west elm
Downtown Portland
164 Middle Street
Portland, ME 04101
PROJECT #006-160335.00

A1 OVERALL FIRST FLOOR / FINISH PLAN
1/8"=1'-0"

A-110

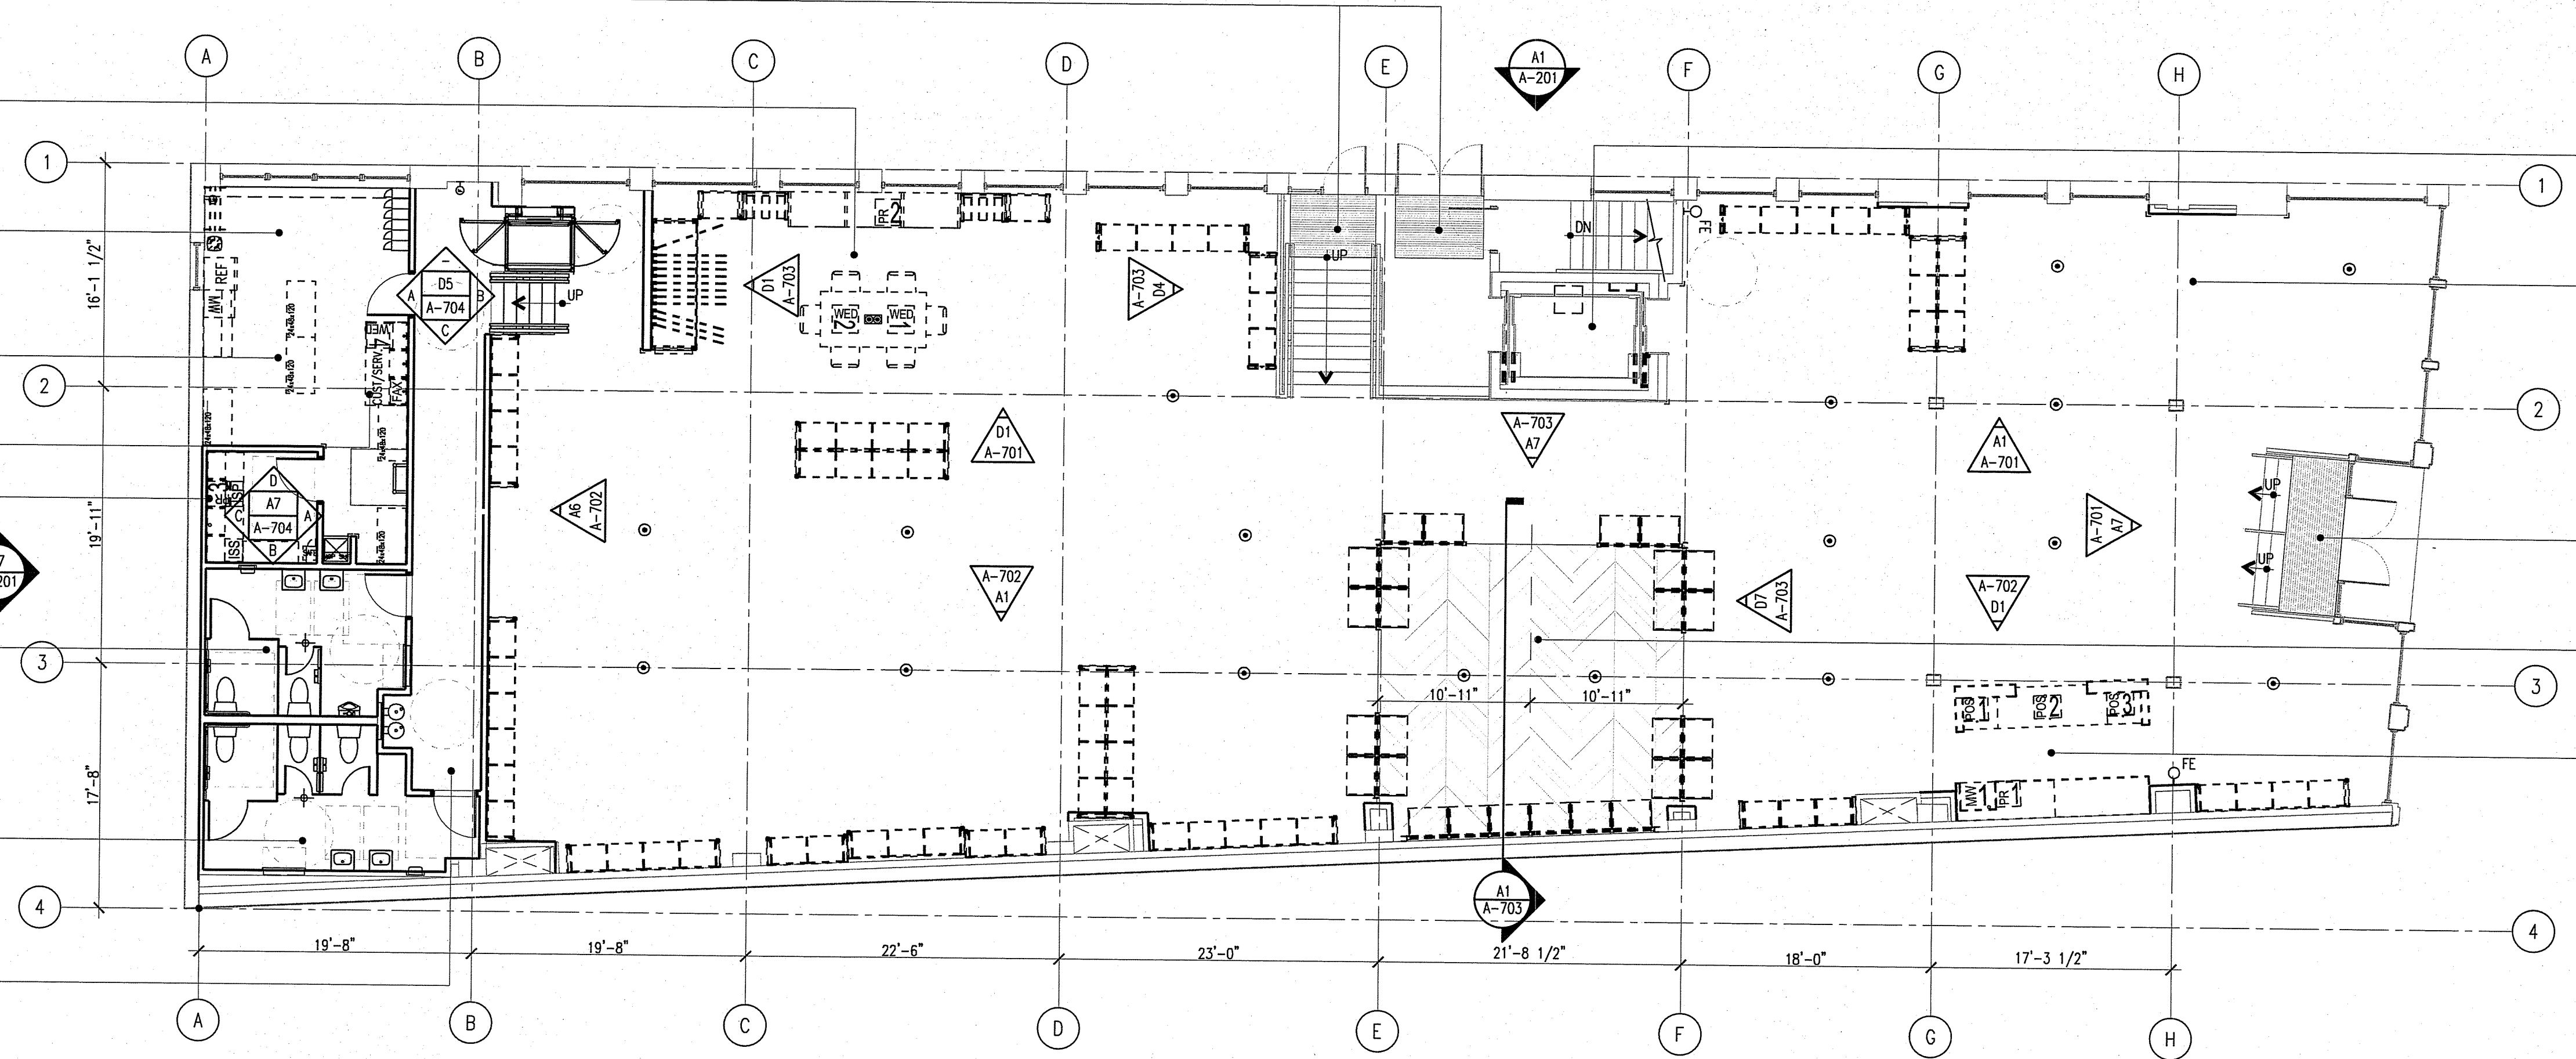
RESPONSE: THE ROOF ACCESS LADDER IS IN THE LANDLORD'S SCOPE.
